## The London Resort Development Consent Order

#### Appendix 12.7 Non-statutory consultee responses to the Preliminary Environmental Information Report

Document reference: 6.2.12.7  
Revision: 00

**Appendix 12.7 Non-statutory Consultee Responses to the Preliminary Environmental Information Report (Relevant to Terrestrial and Freshwater Ecology)**

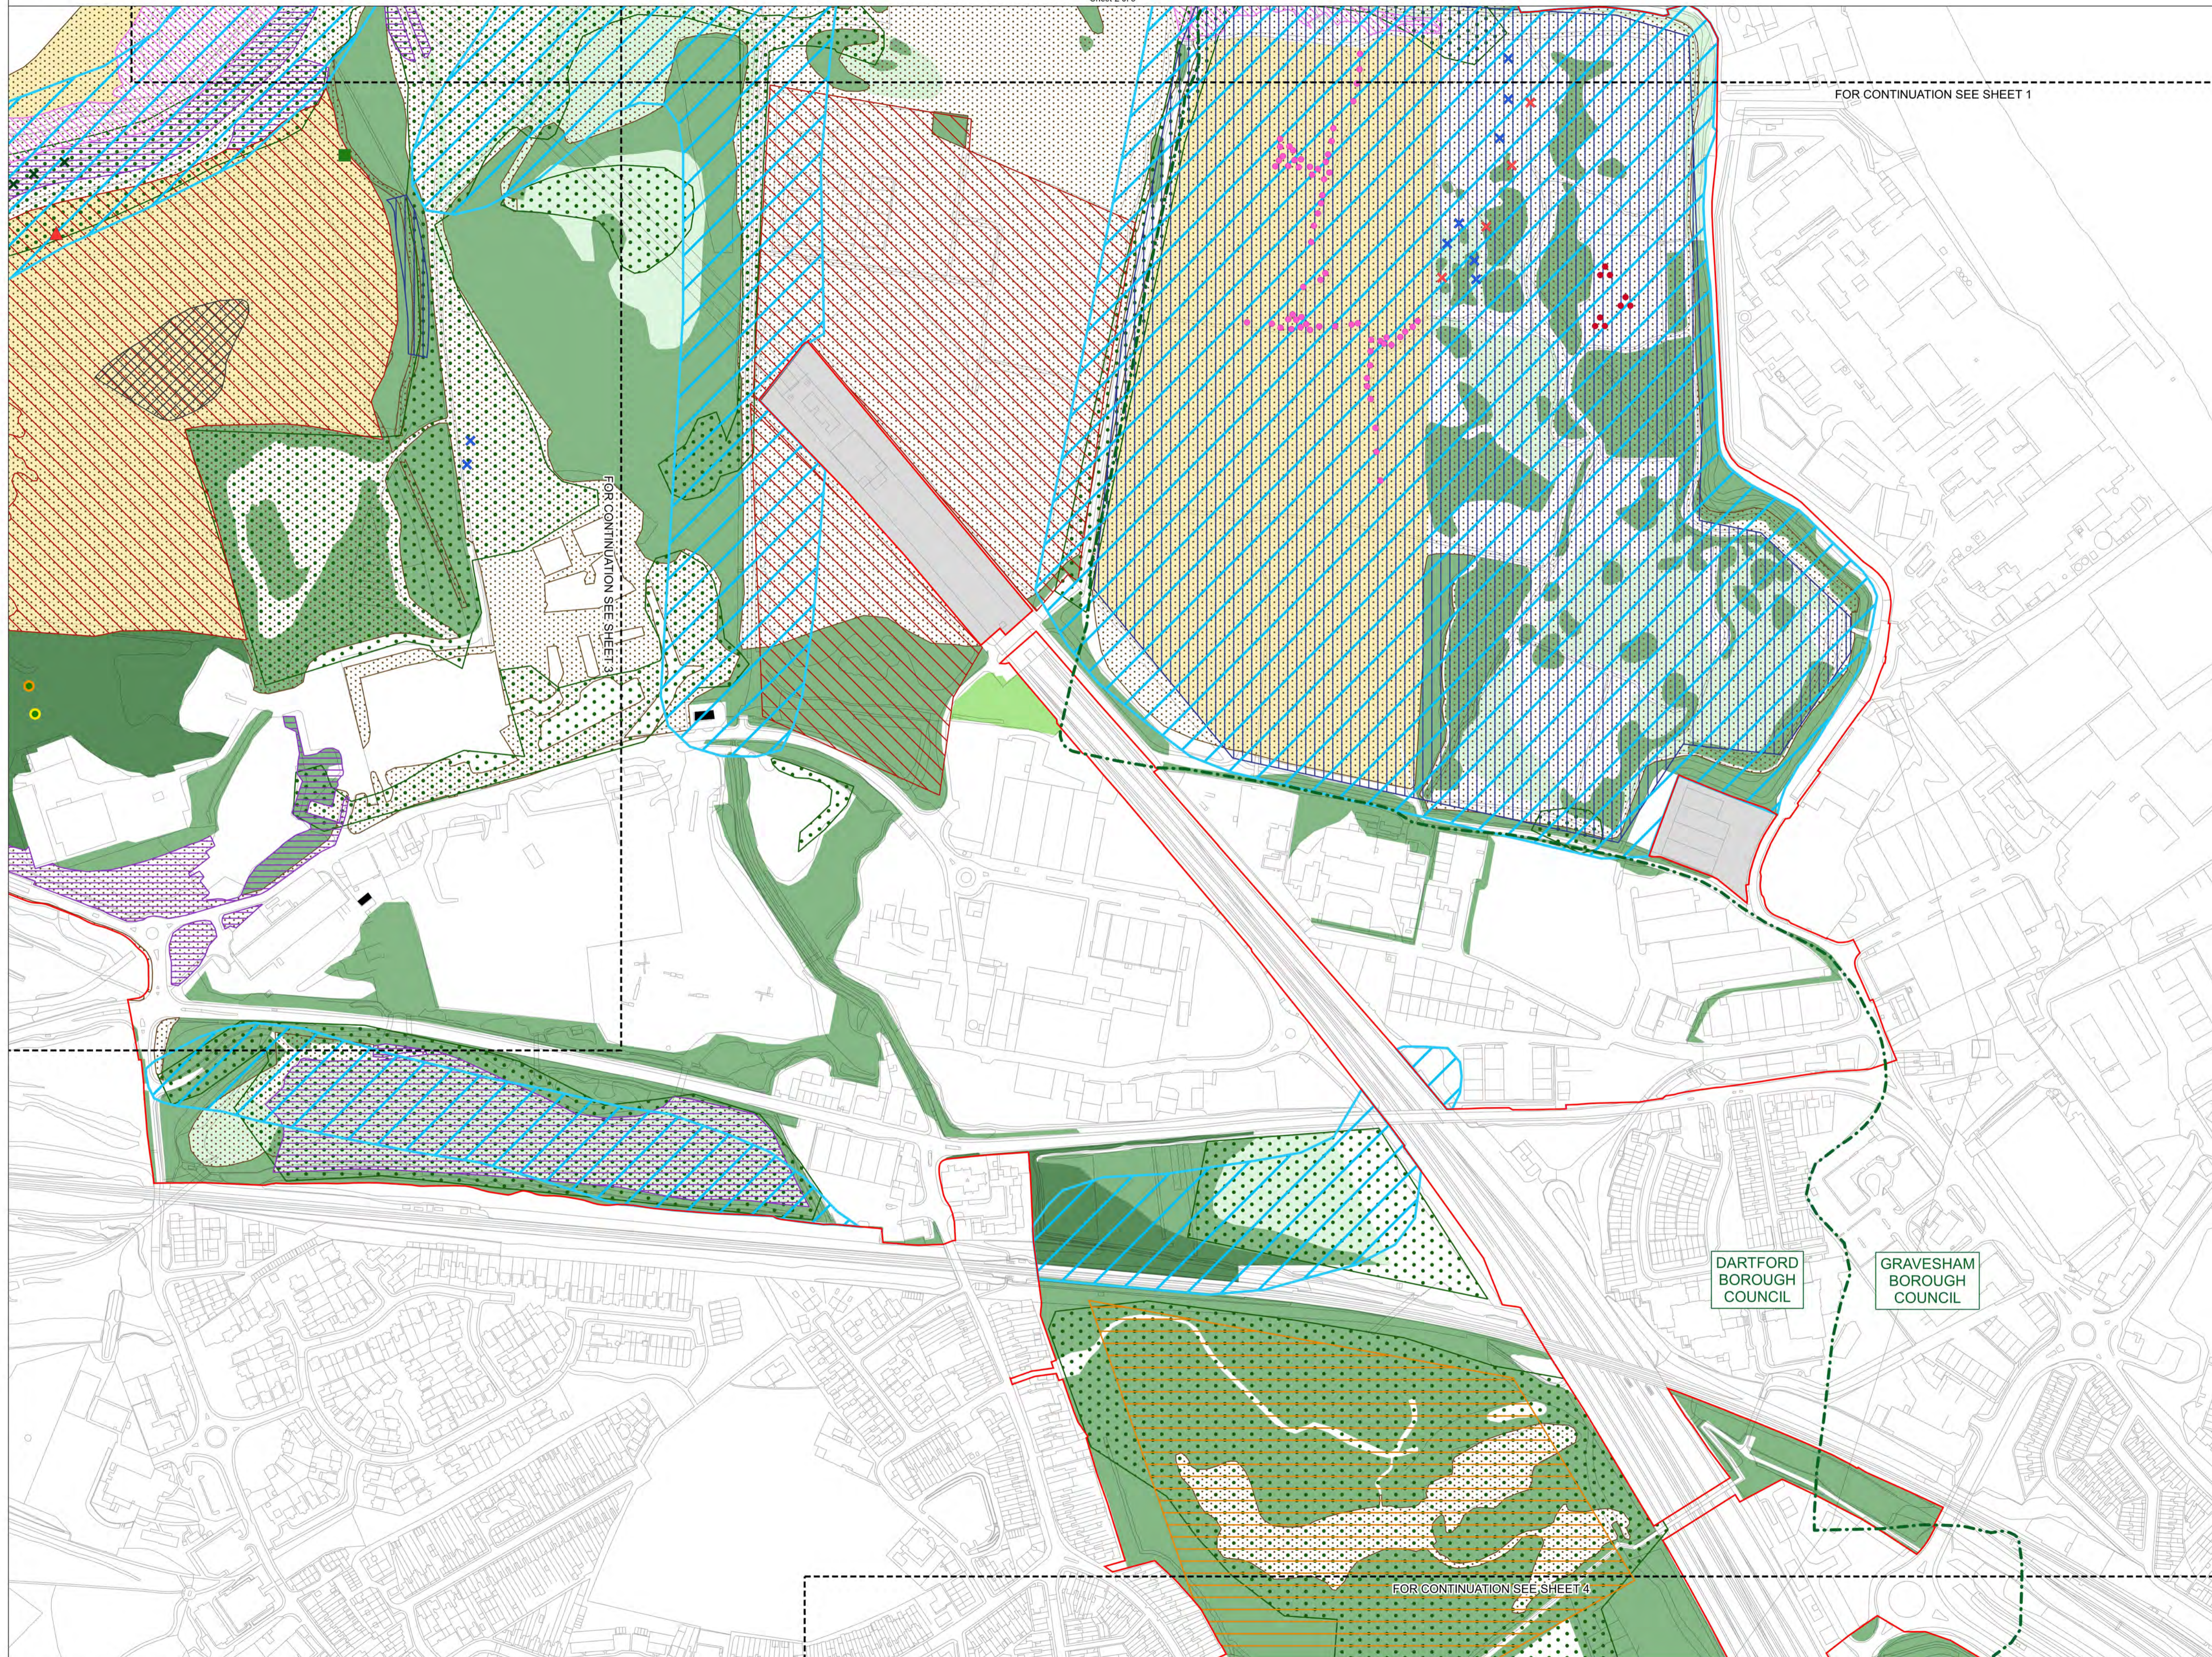
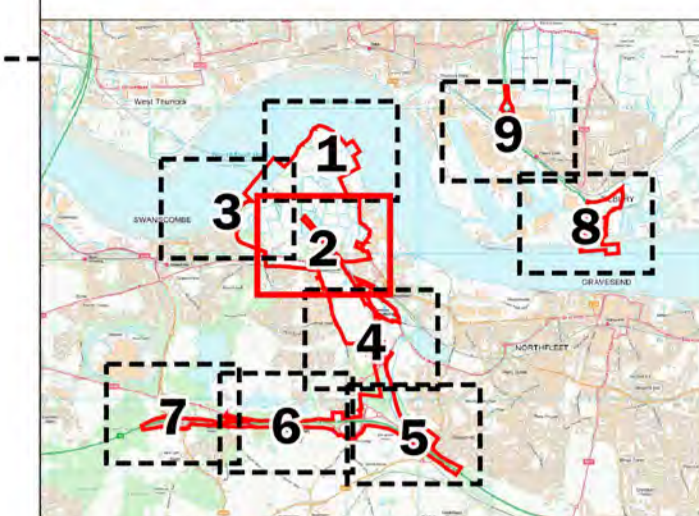
Priority Habitats - OMHPDL	<p>We are concerned that the PEIR and phase 1 habitat maps attached in Appendix 12.1 significantly under represent the area onsite classified as Open Mosaic Habitat on Previously Developed Land (OMHPDL). We would draw your attention to the qualifying criteria for classification as OMHPDL priority habitat, which are stated as follows:</p> <ul style="list-style-type: none"> <li>•Be at least 0.25 hectares in size</li> <li>•Known history of disturbance at the site or evidence that soil has been removed or severely modified by previous use(s) of the site. Extraneous materials/substrates such as industrial spoil may have been added.</li> <li>•The site contains some vegetation. This will comprise early successional communities consisting mainly of stress tolerant species (e.g. indicative of low nutrient status or drought). Early successional communities are composed of a) annuals or b) mosses/liverworts or c) lichens or d) ruderals or e) inundation species or f) open grassland or g) flower-rich grassland or h) heathland.</li> <li>•The site contains un-vegetated, loose bare substrate and pools may be present.</li> <li>•The site shows spatial variation, forming a mosaic of one or more of the early successional communities plus bare substrate, within 0.25 ha.</li> </ul>	<p>The extent of OMHPDL across the Project Site has been re-assessed based upon the priority habitat inventory, historic satellite data and site knowledge. The area described as OMHPDL is significantly larger than previously assessed, but does not include areas of dense scrub or obviously capped/landscaped habitat. Although the Priority Reference was used as part of the re-assessment process, professional judgement was used to include/exclude areas considered to not meet the criteria for inclusion as OMHPDL. The updated assessment is shown in Chapter 12: Terrestrial and Freshwater Ecology and Biodiversity (Document Reference 6.1.12).</p>

Impacts on Open Mosaic Habitat on Previously Developed Land	The PEIR and Phase 1 habitat maps have failed to accurately calculate the extent of OMHPDL in the application, which prevents any meaningful assessment of the impact on the habitat type from being made. The Priority Habitat description for OMHPDL clearly identifies that only small, localised areas of bare ground are required, alongside spatial variation, a history of disturbance, a mosaic of habitats which can include open grasslands and even allows for open water and scattered scrub over 10-15% of the area. Buglife considers the vast majority of the habitat area being directly lost to the footprint of the proposed development to meet the OMHPDL criteria. However, the PEIR suggests that the site supports only 3ha, as a result of a misinterpretation of the OMHPDL criteria in the Phase 1 habitat assessments which have focused the obviously bare ground and early successional areas of the site, which is far too narrow an assessment of the habitat. Incorrectly identifying and assessing the individual habitat types within the site mosaic, rather than assessing in combination as OMHPDL can lead to extremely different assessments of the value of sites for invertebrates, as individual habitat areas are assessed as being small and of lower value than the overarching mosaic created.	<p>The extent of OMHPDL across the Project Site has been re-assessed based upon the priority habitat inventory, historic satellite data and site knowledge. The area described as OMHPDL is significantly larger than previously assessed, but does not include areas of dense scrub or obviously capped/landscaped habitat. Although the Priority Reference was used as part of the re-assessment process, professional judgement was used to include/exclude areas considered to not meet the criteria for inclusion as OMHPDL.</p> <p>The assessment of potential effects upon the OMHPDL and associated invertebrate population has been reviewed and updated following consideration of comments from consultees. A range of inherent mitigation measures, as well as additional onsite and off-site mitigation, are provided as part of the Proposed Development. Full details are provided in Chapter 12: Terrestrial and Freshwater Ecology and Biodiversity (Document Reference 6.1.12). Specifically, in regard to invertebrates, mitigation is detailed within the 'Invertebrate Mitigation Strategy' enclosed within Appendix 12.3: Ecological Mitigation and Management Framework (Document Reference: 6.2.12.3). Principles for the off-site mitigation are provided within Appendix 12.10: General Principles for Offsite Ecological Mitigation (Document Reference 6.2.12.10).</p>
